People For The Plains

The following is a submission against the Santos Environmental Impact Statement for the Narrabri Gas Project, Application Number SSD 6456.

Figure 7-1 Water sharing plans applicable to the project

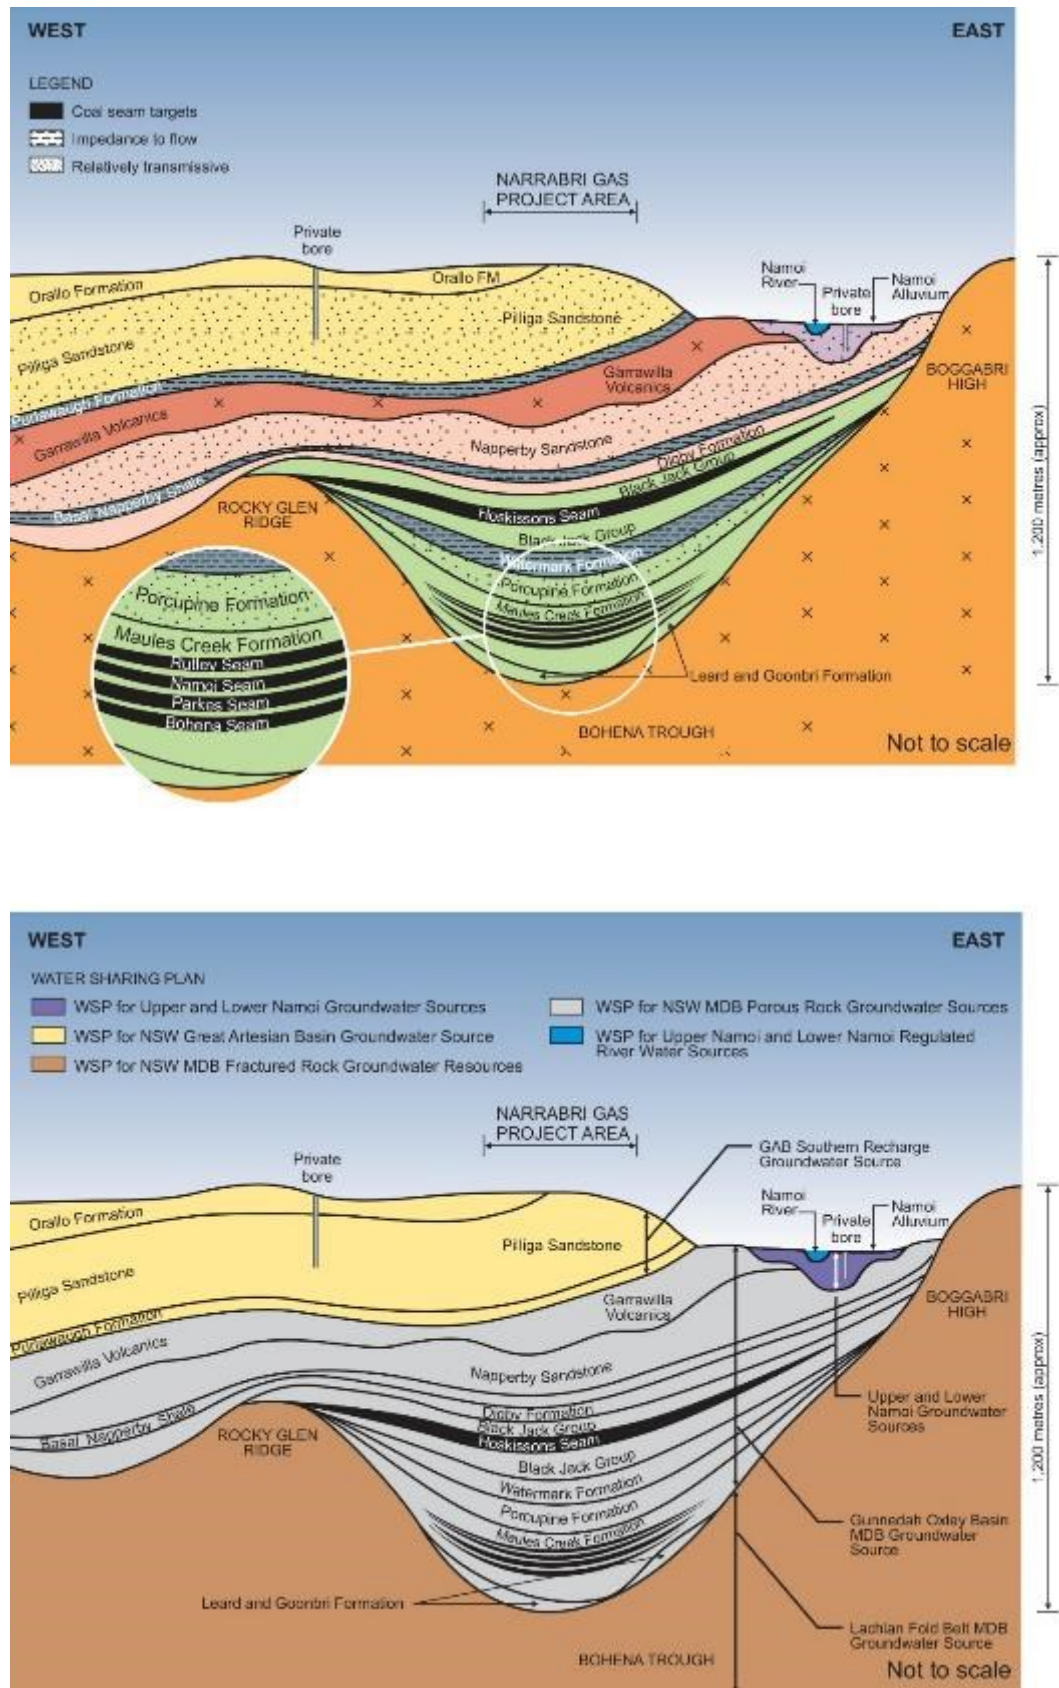
This EIS says that a 10:1 flow rate versus the discharge rate is required to attain good dilution of the introduced waters. This may mean that the creek flow rate past the discharge point is not obtainable.
